Date: 04/24/2024

Re: **Overhanging Sill Plate**
Location: Lot 69 The Farm at Neill's Creek (337 Winding Creek Dr. (Lillington, NC))
JDS Project No.: RDU2404233
Date of Inspection: 04/24/2024

HOUSE NAME:	CALLAWAY
DRAWING TITLE	FIRST FLOOR PLAN

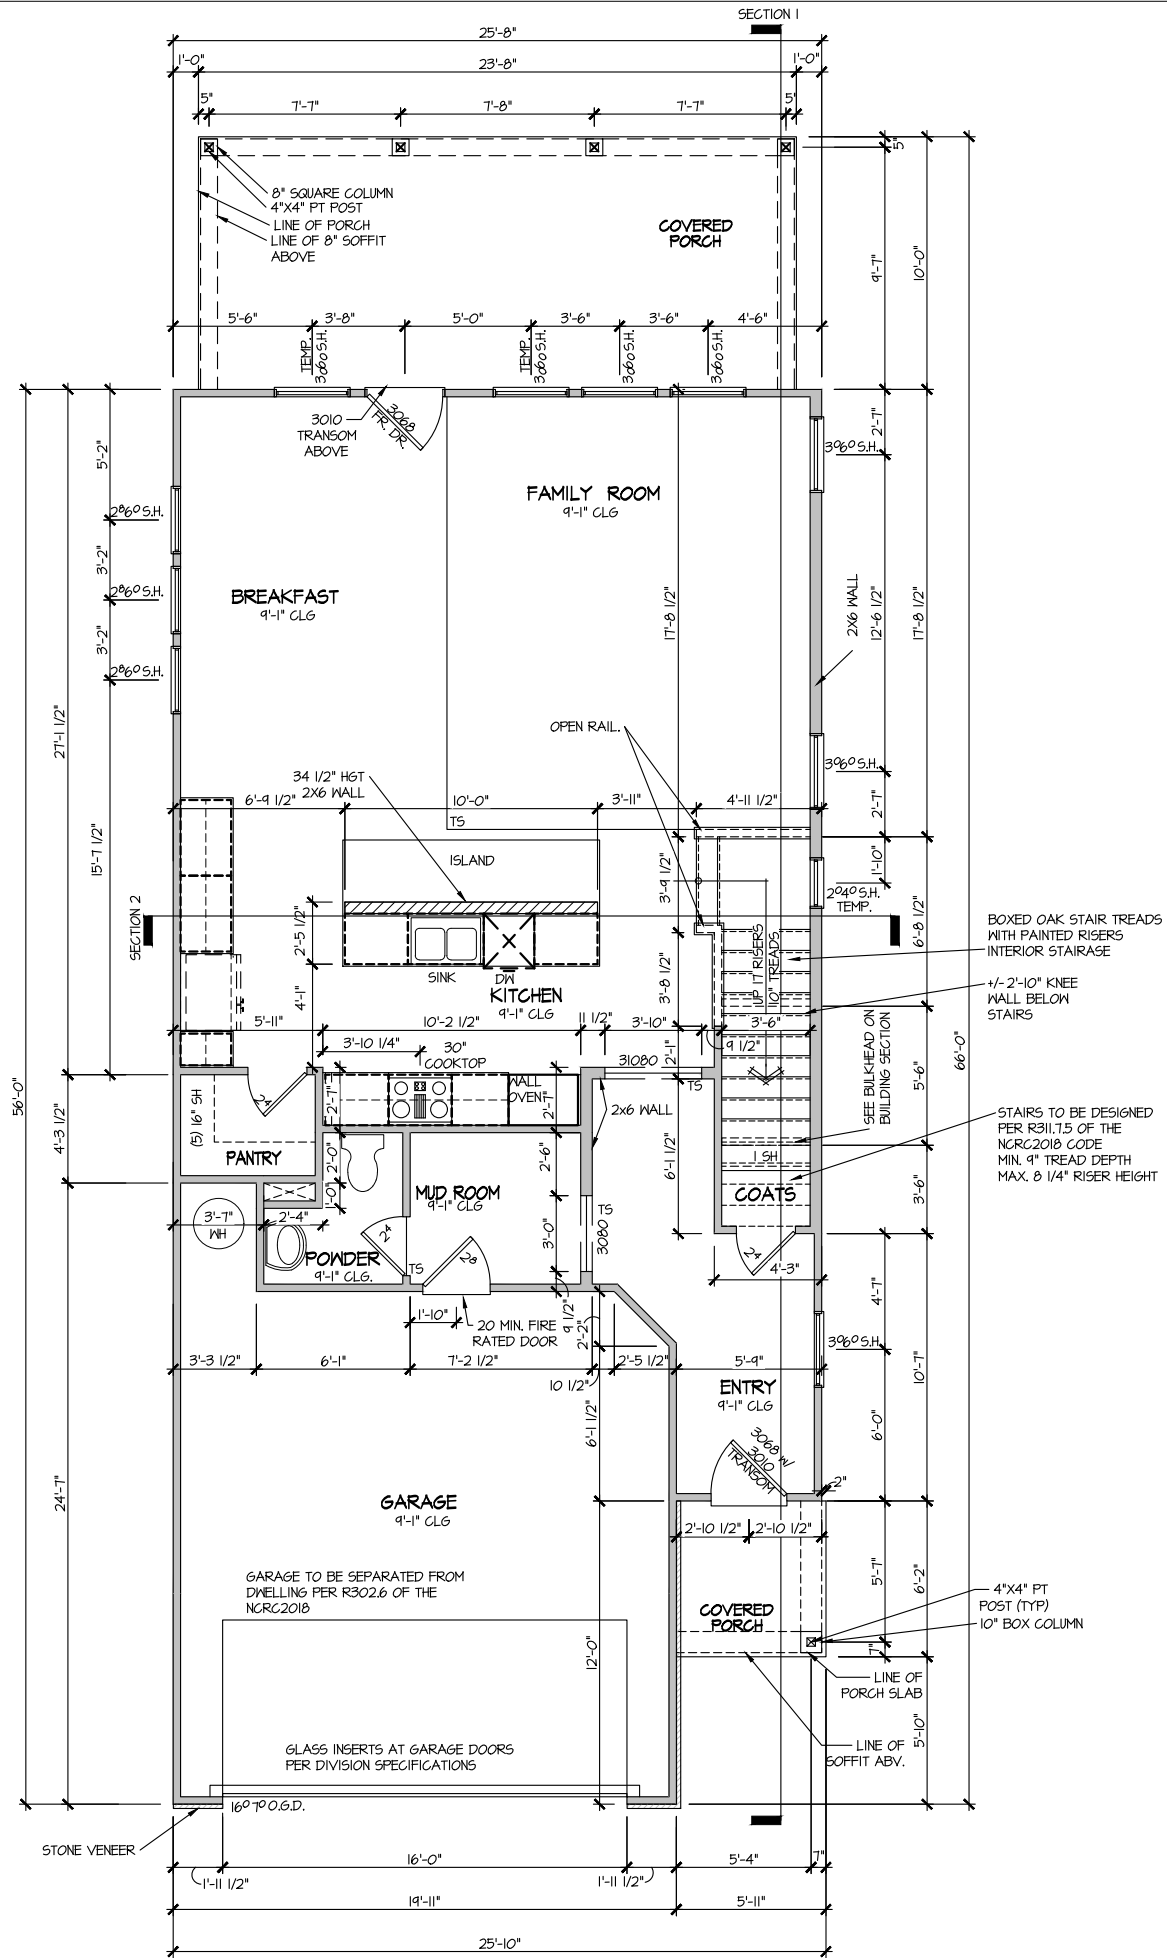
The client requested an evaluation of an overhanging sill plate located at the left wall of the front porch extending to the right-wing wall of the garage. The max width observed is approximately 2" at the far end. The wall is 2x6 frame, and the entire wall will have (2) 2x6 studs.

Based on our observations and review, the wall is adequate as it is installed, no repairs are required.
